Our ref: WA/2023/130772/01-L01

Your ref: 23/02098/OUT

Begbroke Science Park and Surrounding Land

Objection 1 – Flood risk

Figure 4.1: Model domain and 1D/2D channels

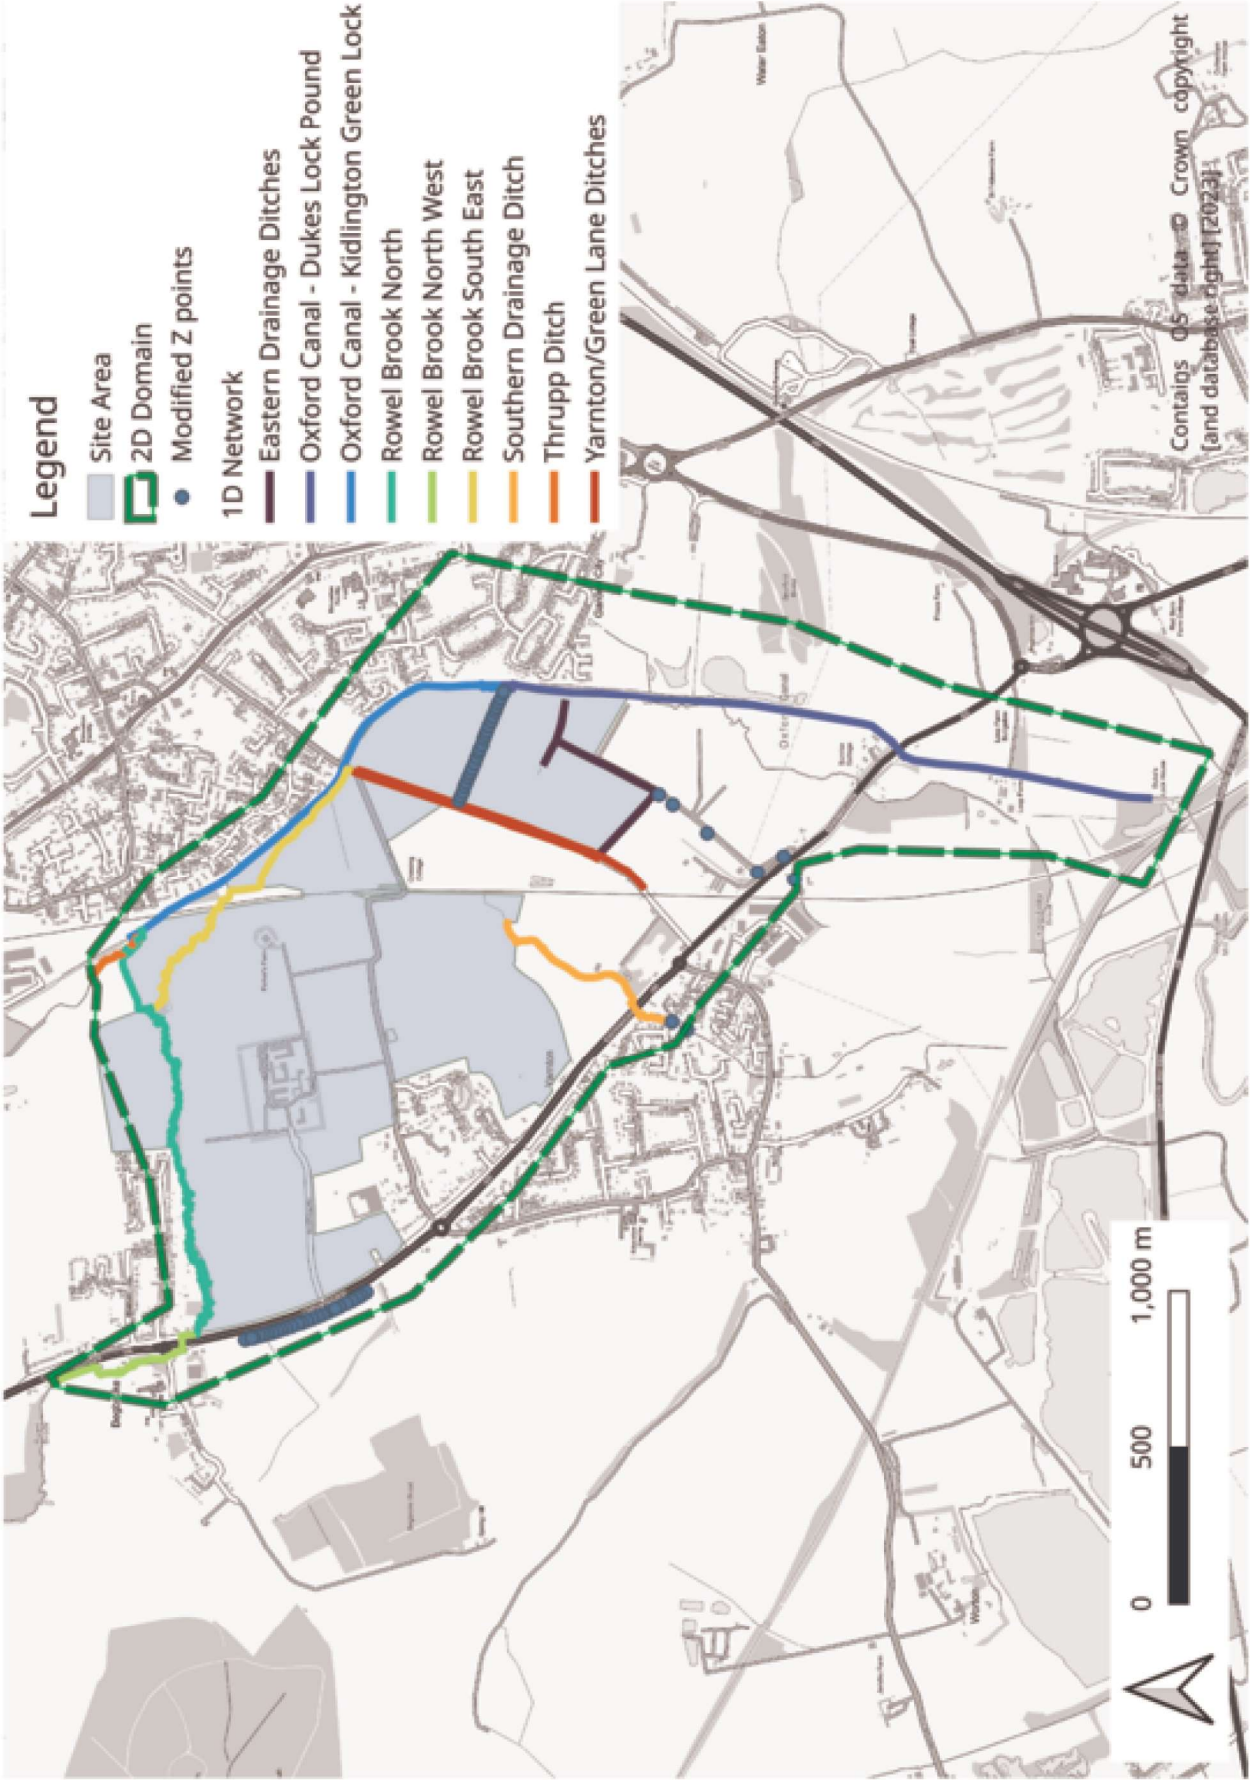
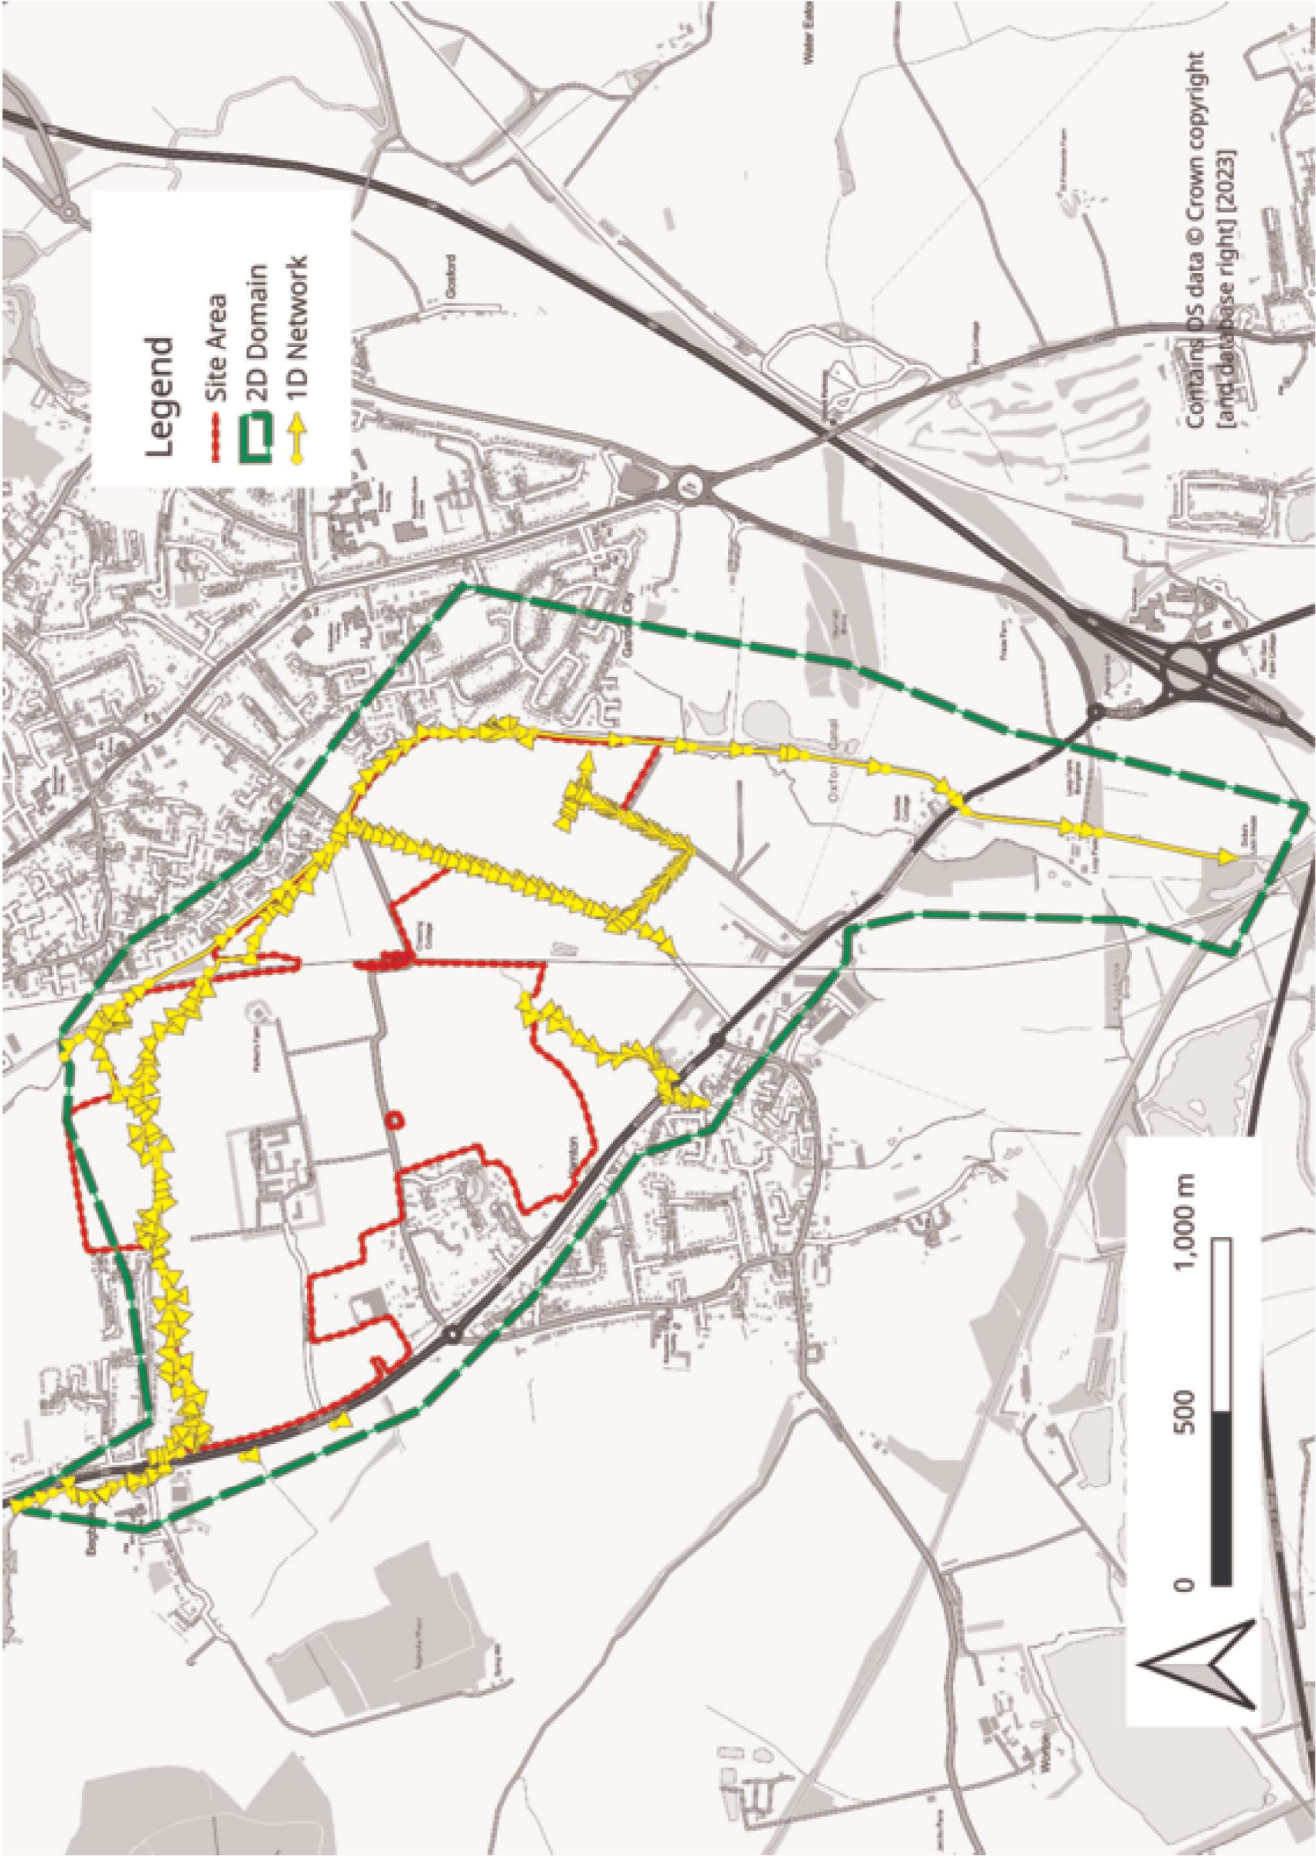
- Significant issues relating to 1D and 2D channel width representation throughout the model which could influence model results and needs to be addressed.
- The applicant has not provided a survey of the canal – please can this be provided for the next review so that we can assess the assumptions that have been made?

- There is a lack of information as to where elevations have been taken from for the various modifications to the underlying topography e.g. 2d_zsh_TOP_BANK_v12-A_P.shp
- **We have requested the model files associated with the model sensitivity tests for this review but they were not submitted in time for the first review. We welcome that sensitivity tests and site photos have now been submitted and we will review these in any future consultation on this planning application following the submission of further modelling information to overcome our other concerns.**

Figure 5.1: Maximum modelled depth in the 3.33% AEP event, 11 hour storm duration

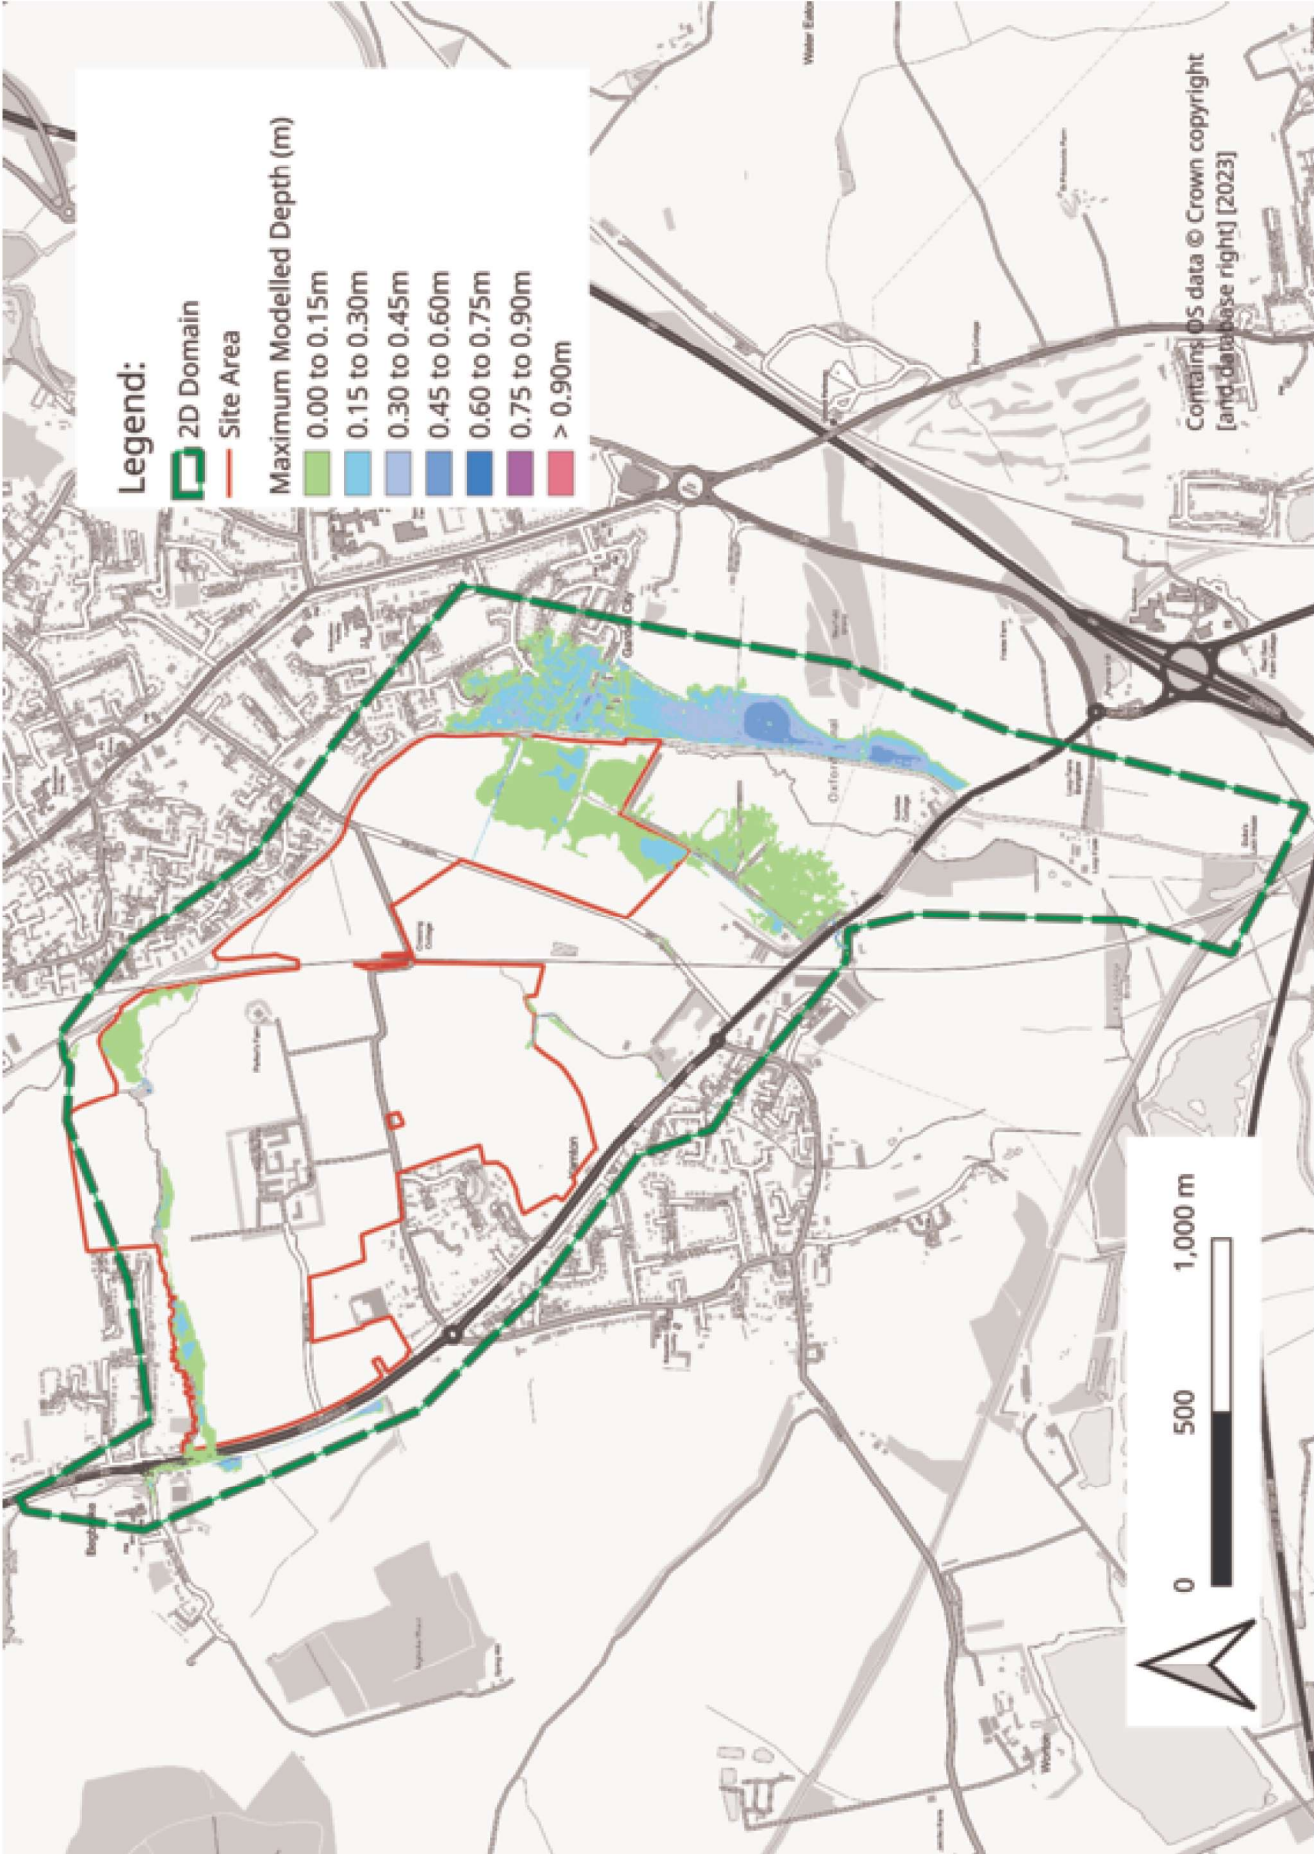
Flood Zone 3b (functional floodplain) is where water has to flow or be stored in times of flood and should be safeguarded from development. In accordance with Figure 9 of the FRA, part of the application site is shown to lie within the 3.3% AEP flood outline as so is identified as within Flood Zone 3b (the functional floodplain). This area is in the south of the site near the proposed secondary school. More information is required on what is proposed within this flood extent as it appears in close proximity to land level changes and 'more vulnerable' development, which would be inappropriate in Flood Zone 3b.
